Appeal Decision

Appeal Ref: APP/R5510/D/22/3305401

7 Elgin Drive, Northwood, Middlesex HA6 2YR

- The appeal is made under section 78 of the Town and Country Planning Act 1990 against a refusal to grant planning permission.
- The appeal is made by Mr and Mrs Sheikh against the decision of London Borough of Hillingdon.
- The application Ref 55600/APP/2022/1990, dated 21 June 2022, was refused by notice dated 17 August 2022.
- The development proposed is balcony with timber railing & decking.

| Balcony  | 01    |

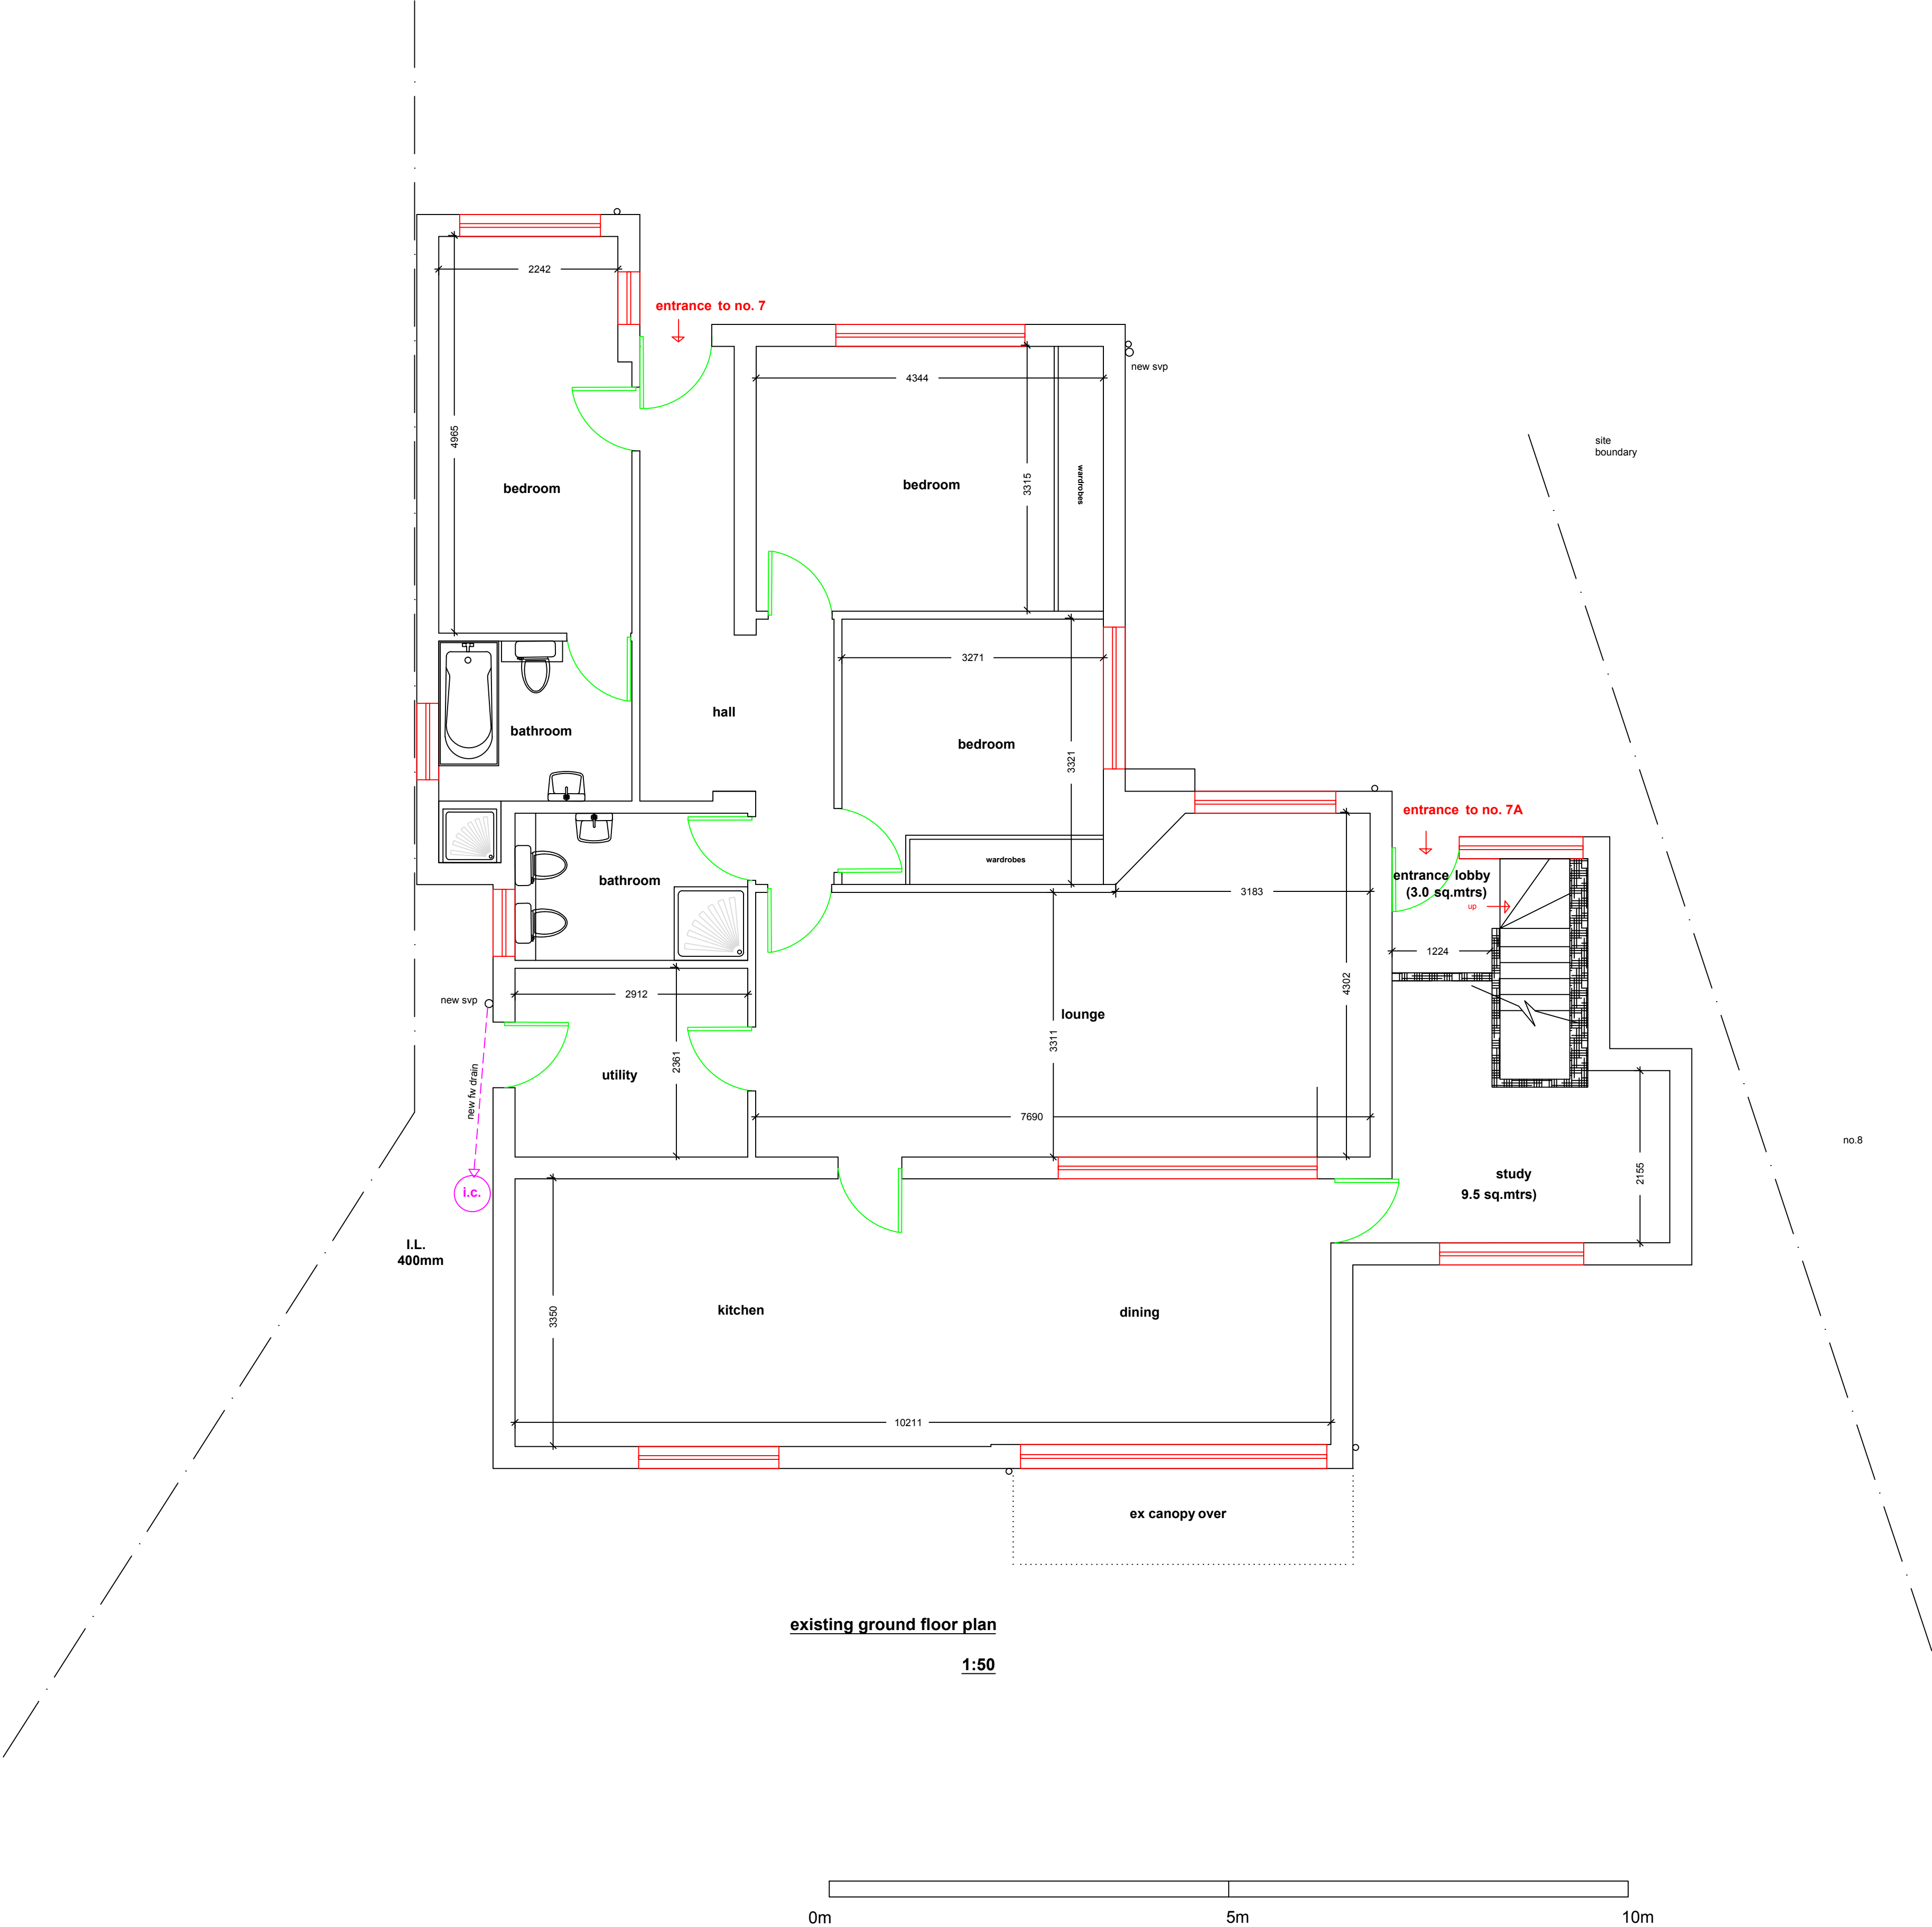
8. From the submitted plans and my observations at the site visit, the balcony appears as a lightweight timber structure with timber railings, shown on the submitted plans as being 'min 1100mm' high, enclosing the decking that is shown as measuring some 3.8m by 4.14m. The appeal proposal is a prominent feature of the rear elevation of the property, being situated at a first floor level above the existing single storey rear extension.

9. Consequently, while the appeal proposal is not a substantial structure, it nonetheless is of some size and scale in itself and in proportion to the appeal property. Furthermore, the design and materials used in the construction of the balcony appears at odds with, and poorly related to, the appeal property.

10. Consequently, while views of the balcony are largely limited, nonetheless I find that the balcony appears as an incongruous feature and as a result harms the character and appearance of the appeal property contrary to Policy BE1 of the Hillingdon Local Plan: Part One - Strategic Policies and policies DMHD 1, DMHB 11 and DMHB 12 of the Hillingdon Local Plan Part Two - Development Management Policies and Policies D3 and D4 of the London Plan.
